City of Albuquerque

November 15, 1999

Re: Trumbull Warehouse Grading and Drainage Plan
Engineer's Stamp dated 9-25-99 (L20/D60)

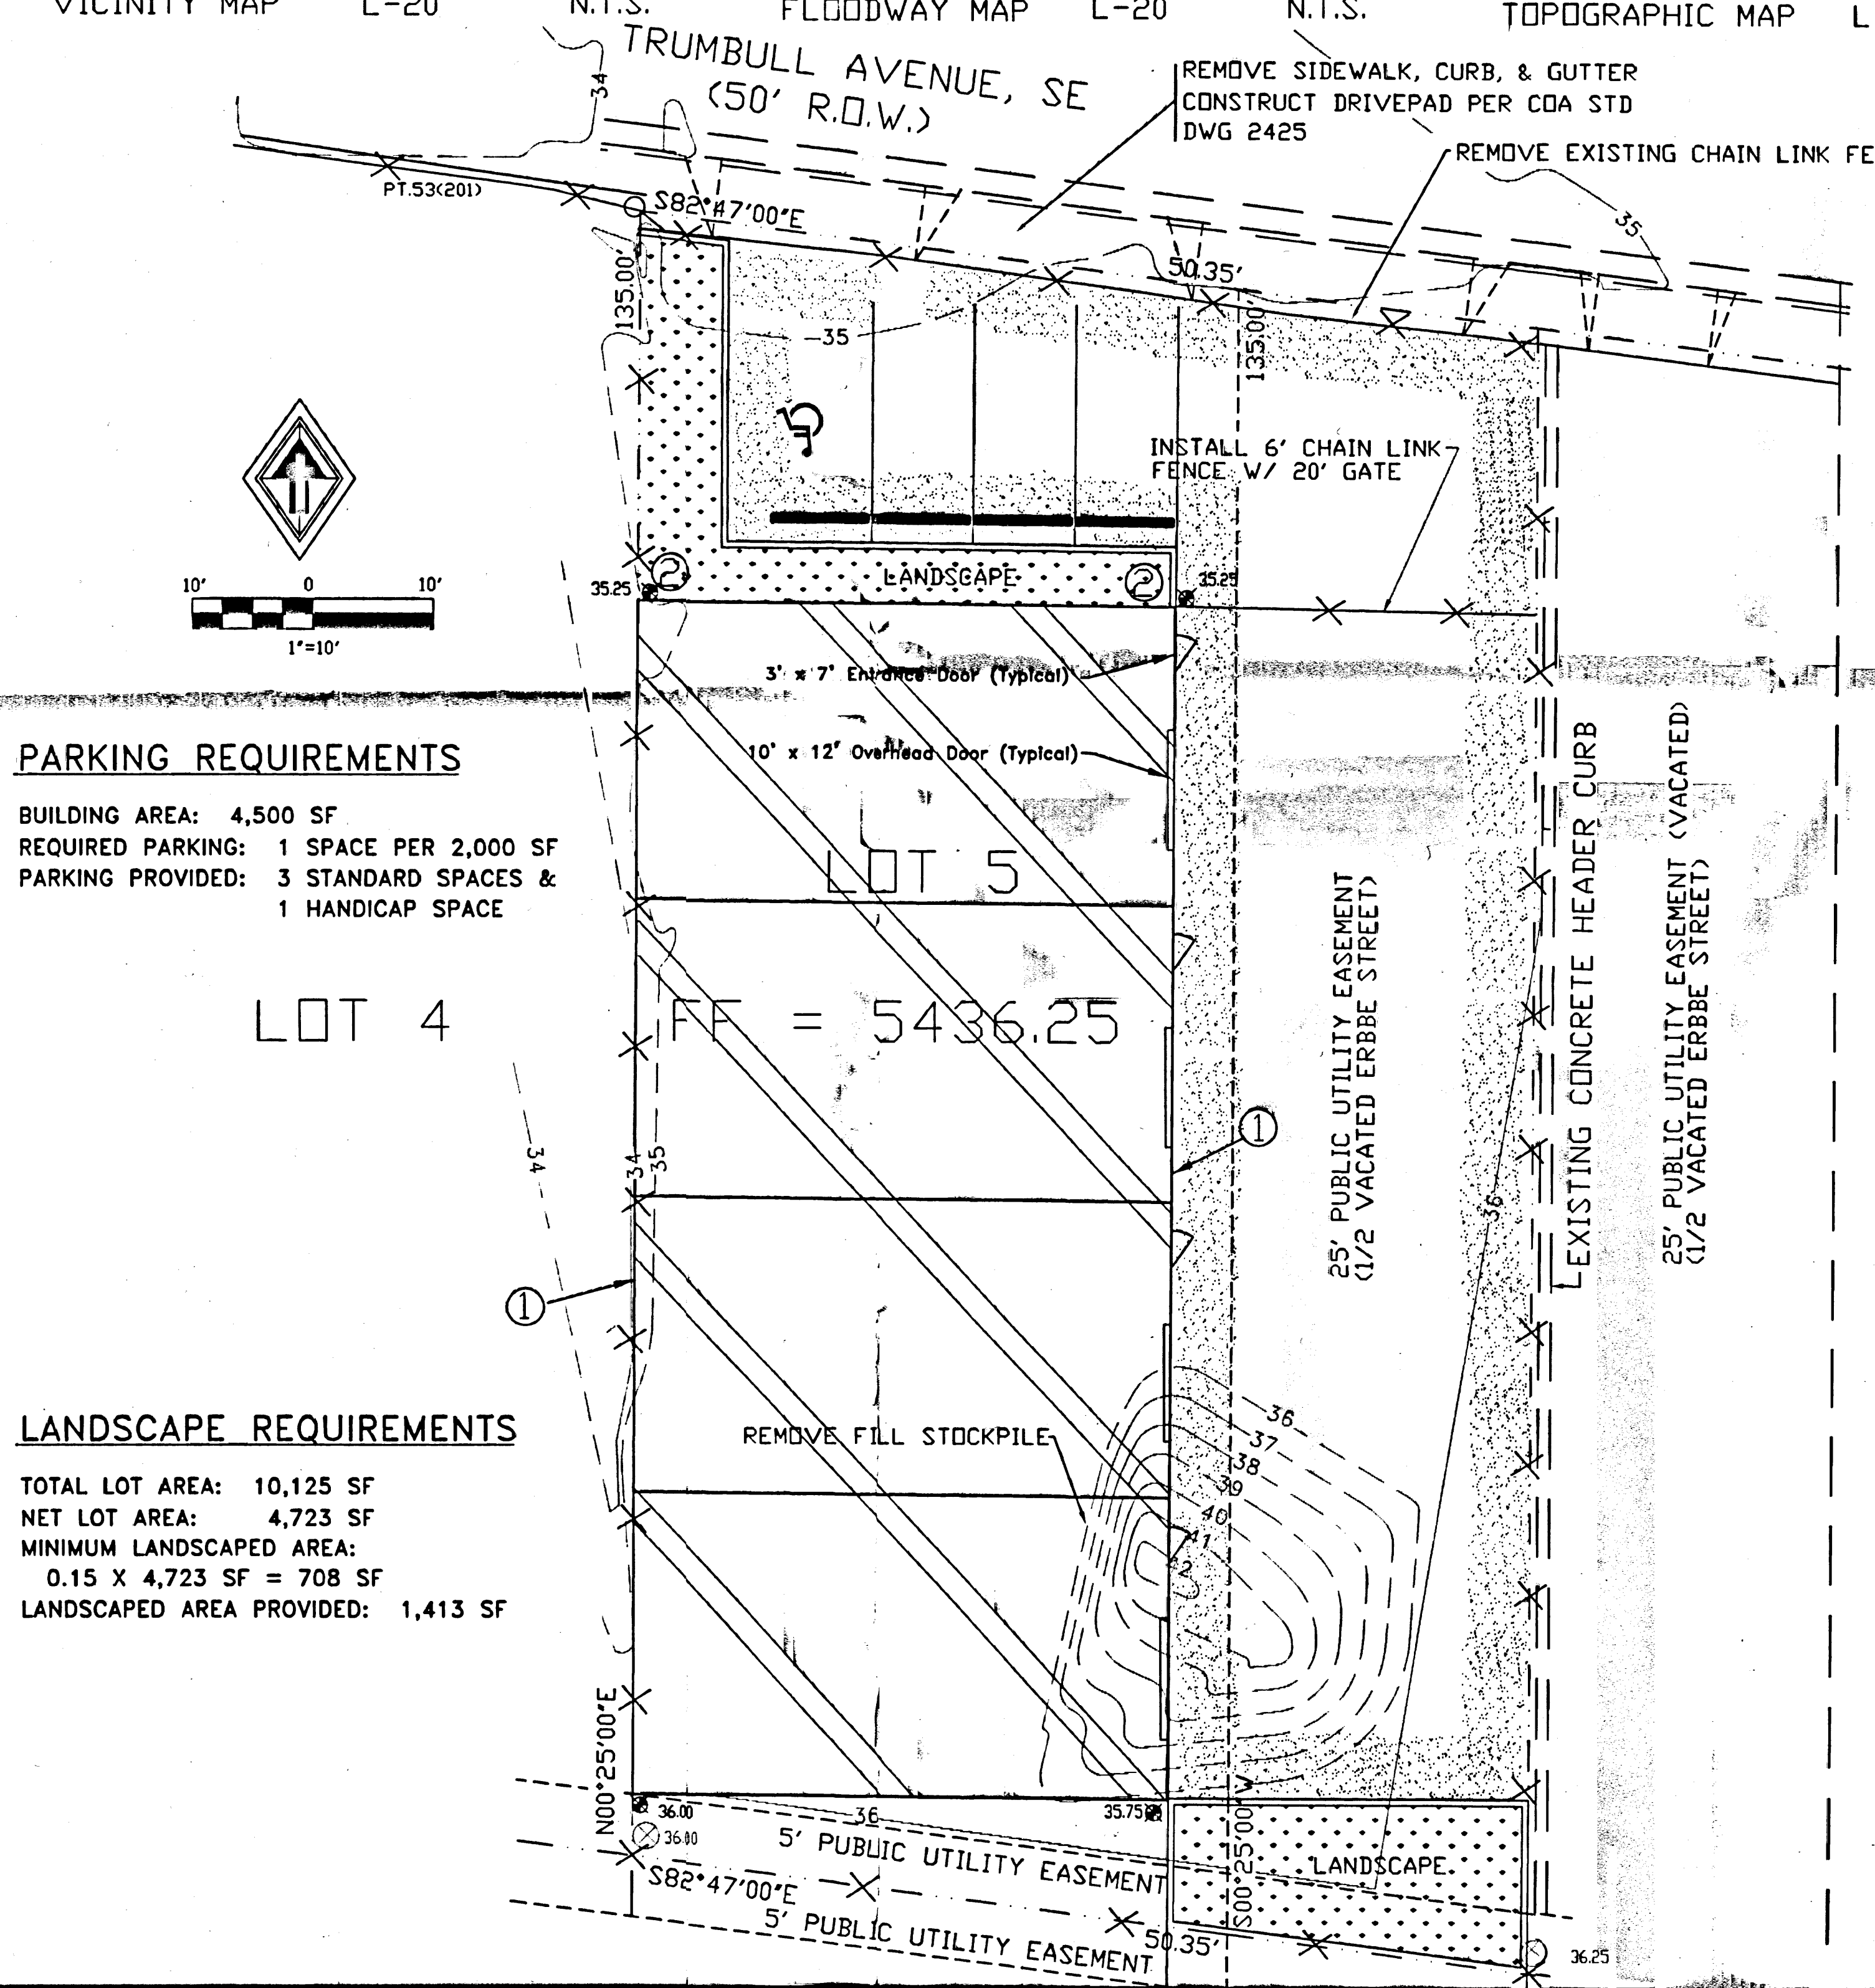
Based upon the information provided in your submittal dated 9-30-99, the above referenced site will not be reviewed until an acceptable Site Plan is submitted to Transportation for the TCL. Please submit a revised drainage plan that matches the Site Plan exactly.

Over numerous examinations and discussions of this Site Plan, it has been determined that the layout of this building and the accompanying parking lot cannot work on this size of lot. The overhead doors, as desired, as they have been shown, require that any large (U.P.S./refuse and larger) vehicle using them must access them by backing into or from the street. This is in violation of current code, as mentioned to all representatives previously bringing this particular plan to my office.

If overhead doors are needed for this application the size of building will need to be reduced the number of doors will need to be reduced, the doors will need to be placed facing the rear of the lot, as has been proposed at previous meetings, and all DPM. standards will need to be followed. Parking and driveways for this building will need to be revised, per DPM. standard, if parking in the front is desired, which will mean shifting the building back.

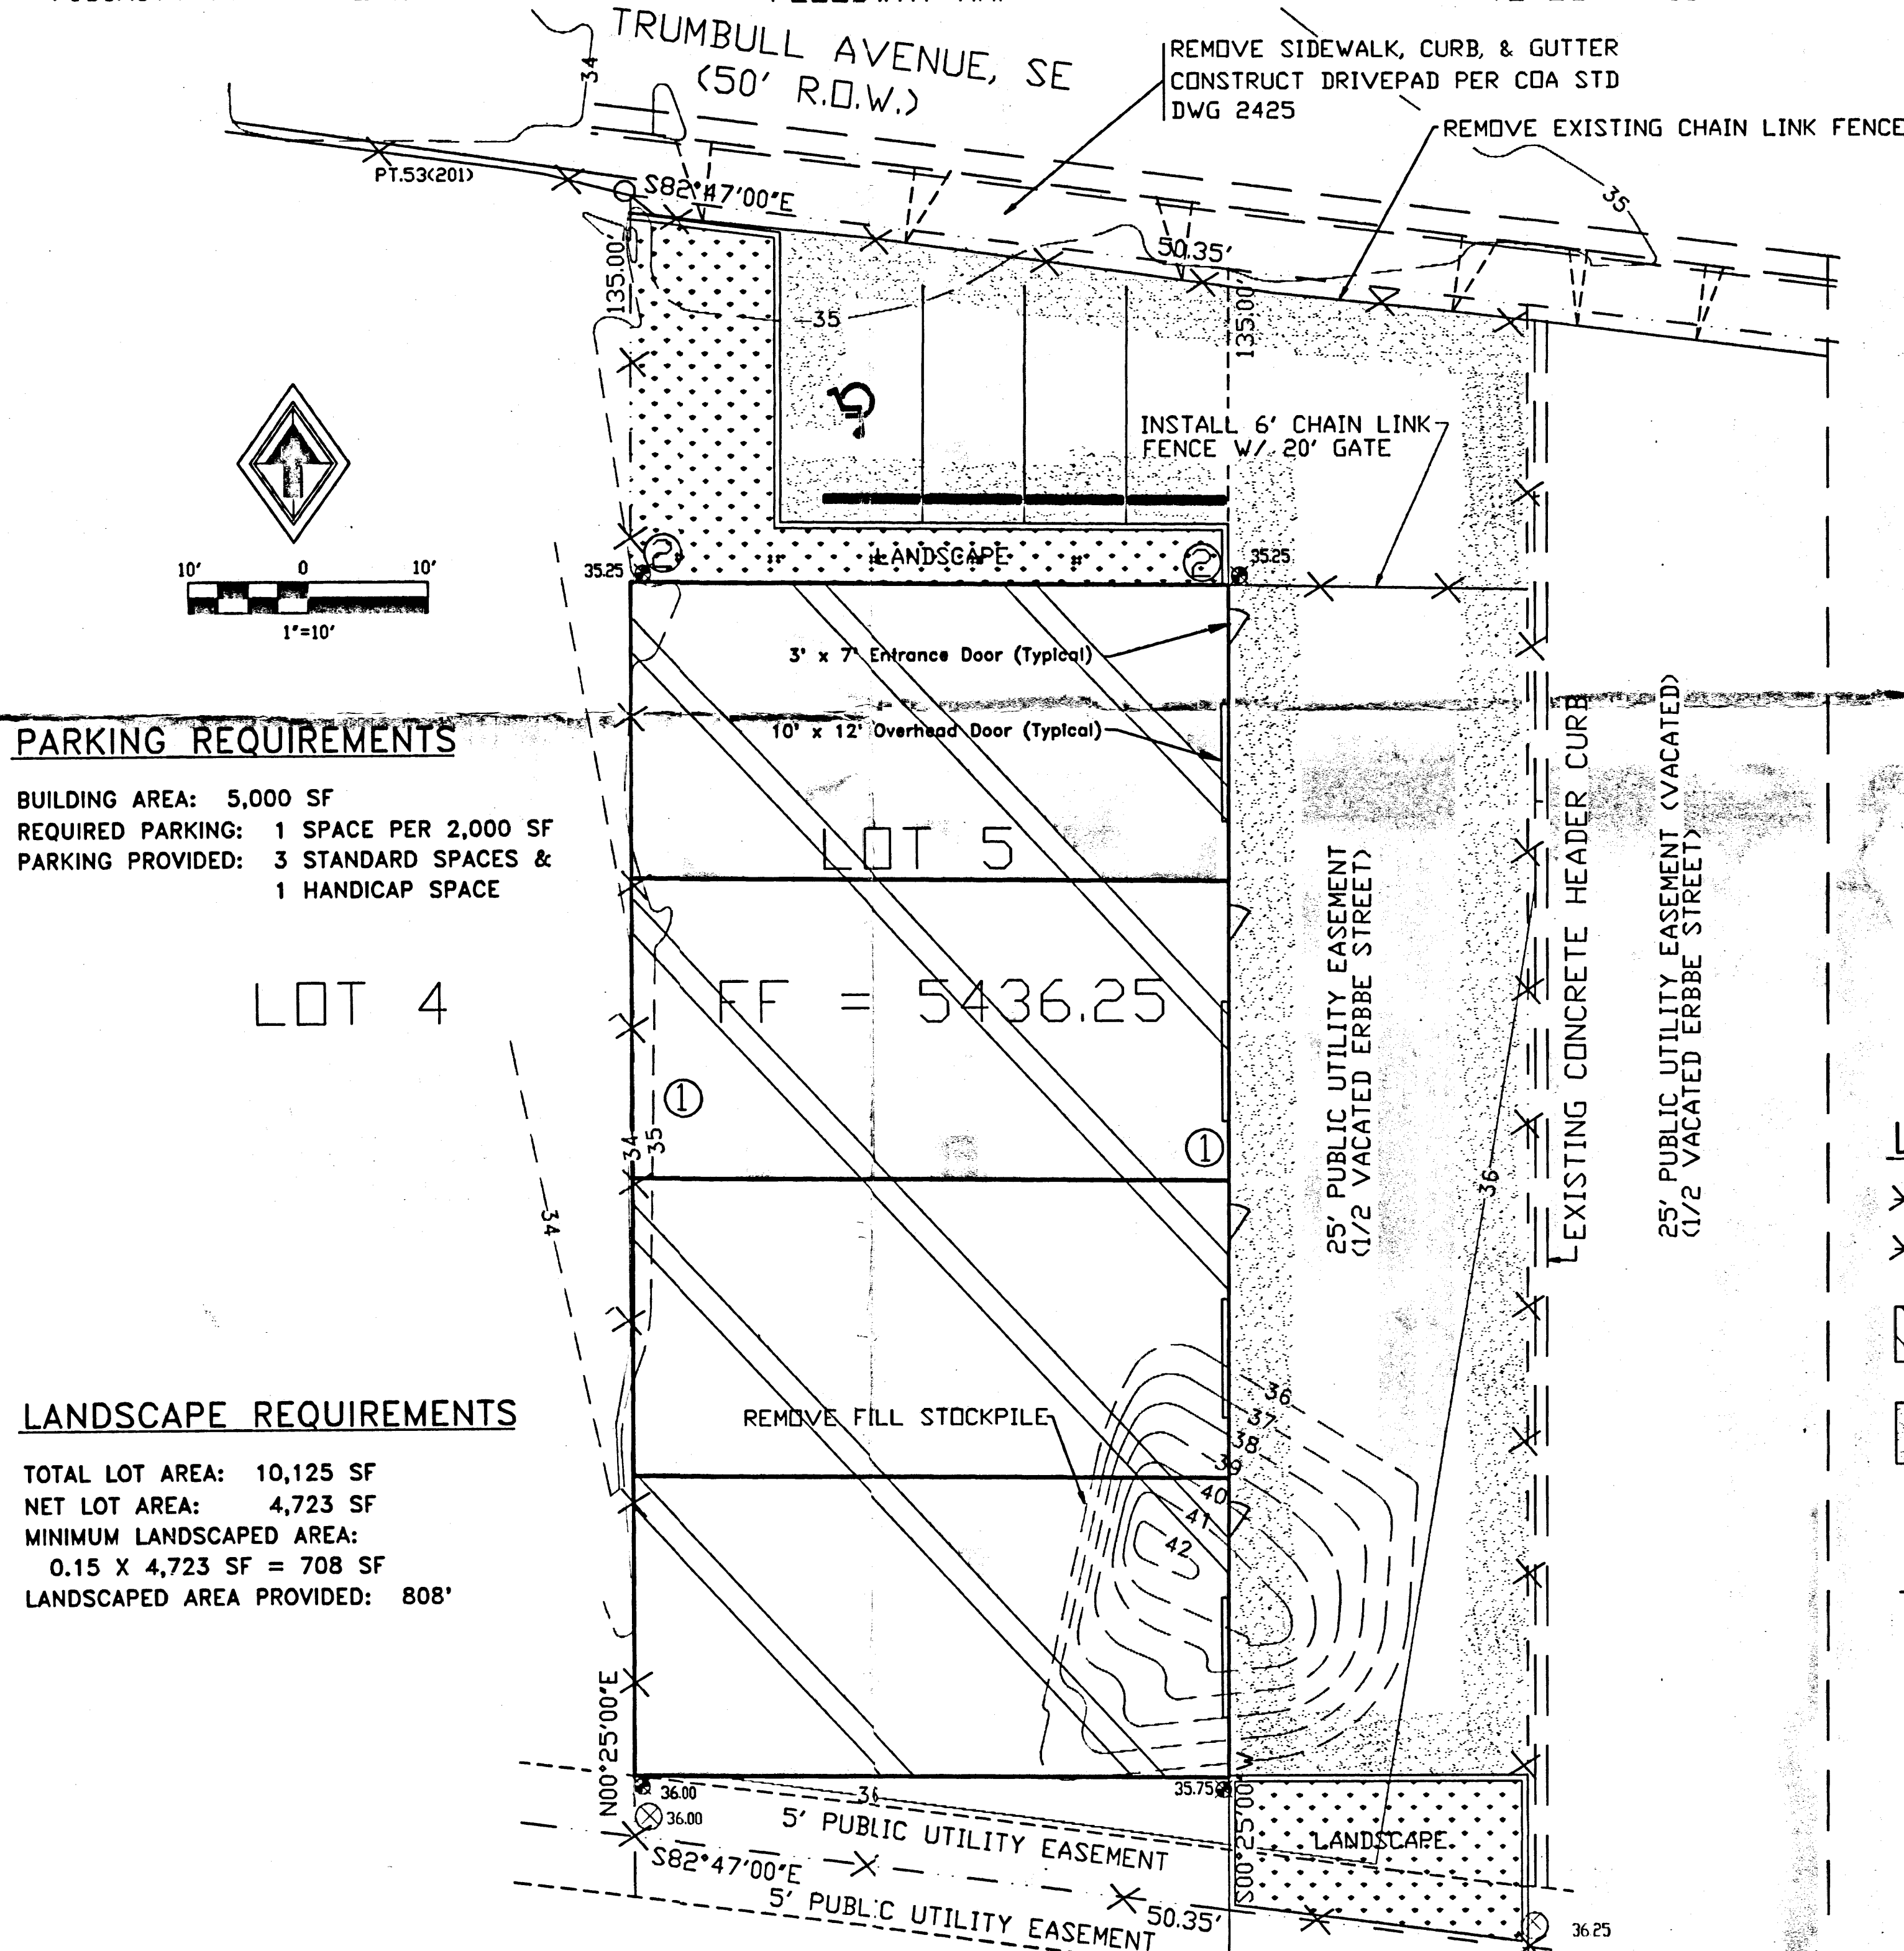
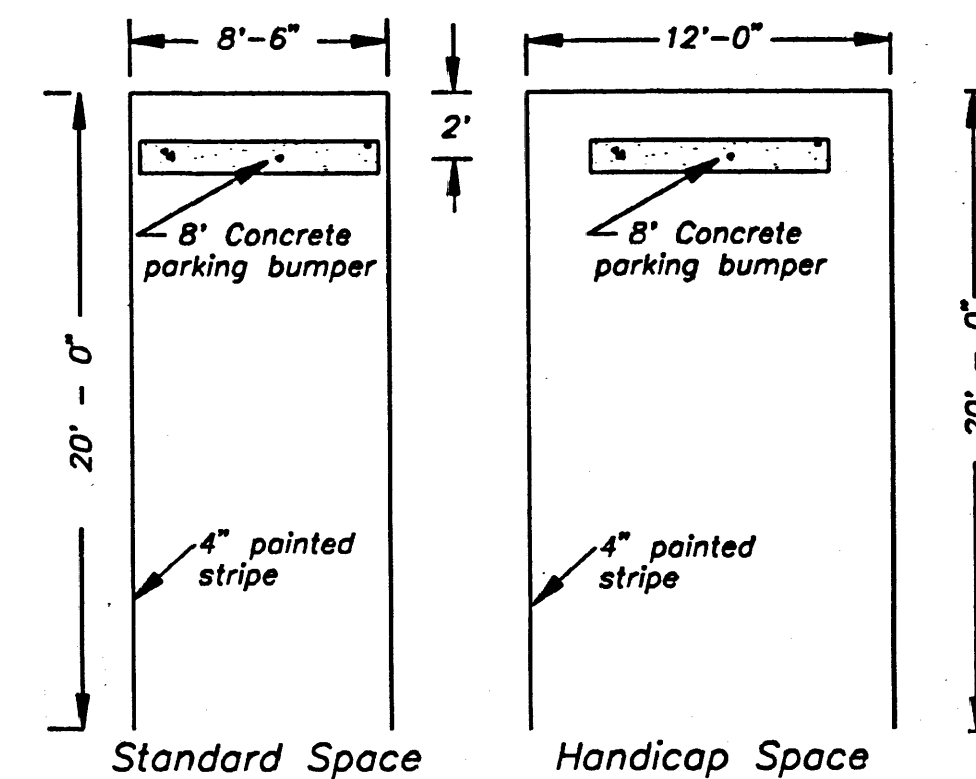
- Proposed use of overhead doors on commercial sites requires that plan reviewer looks for large wheelbase (refuse/UPS) vehicle to be smallest to use doors. As stated in preliminary discussion this site layout will not allow enough room for this condition without backing from or into street. This violates provisions in the DPM, Sect. 23.6B.8b.2 & 23.7B.8. ___ Minim. 30' wide drive aisle needed along service truck route.

- Driveway width providing use by vehicles and access for large service vehicle is too wide to be allowed. Providing two separate driveways for each function cannot be accomplished on this narrow parcel. For this reason, and previous comment, this site layout will need to be redone and full review will then be made.

- New and existing elements noted on the Site Plan must be shown, labelled, and dimensioned correctly and accurately. This includes: curb & gutter, drive aisle, driveway, parking stalls (including H.C.), all curbing, distance from back of street sidewalk to gate, any neighboring driveways, if close to property lines shared with adjacent lots, and fencing (specifically at property lines), etc. ___ Need to see clear differentiation between new construction and existing on Site Plan.

- Show, label, and dimension existing and/or new street sidewalk. City sidewalk ordinance requires minim. 4' street sidewalks along the frontage of all commercial sites being developed.

- 6" high concrete curb, per city standard, must be constructed per DPM Section 23.7 B6. Must prevent overhanging into adjacent property and pedestrian path ___ Label concrete curb, and type (or show detail labelled "typical"), at each individual location or call out double-line style (or equivalent) linework, used to designate curbing, as "typical".

- Minim. 5' wide sidewalk, raised 6" above parking surface, needed at the front of parked vehicles along the front of building. ___ H.C. ramp must be constructed at H.C. parking as part of sidewalk, as shown. ___ Show ramp and slope of ramp using arrows.

- 20' distance needed back from back of sidewalk at driveway for vehicles entering/exiting site.
- Label asphalt and thickness of parking surface per city std. or refer to a detail which illustrates the proposed method of paving and states its equivalency to standard asphalt surfacing.

- Show and label property lines and right-of-way lines.
- Need to see that all existing obstacles in City right-of-way, in existing sidewalks, have been picked up.

- No Refuse enclosure shown.
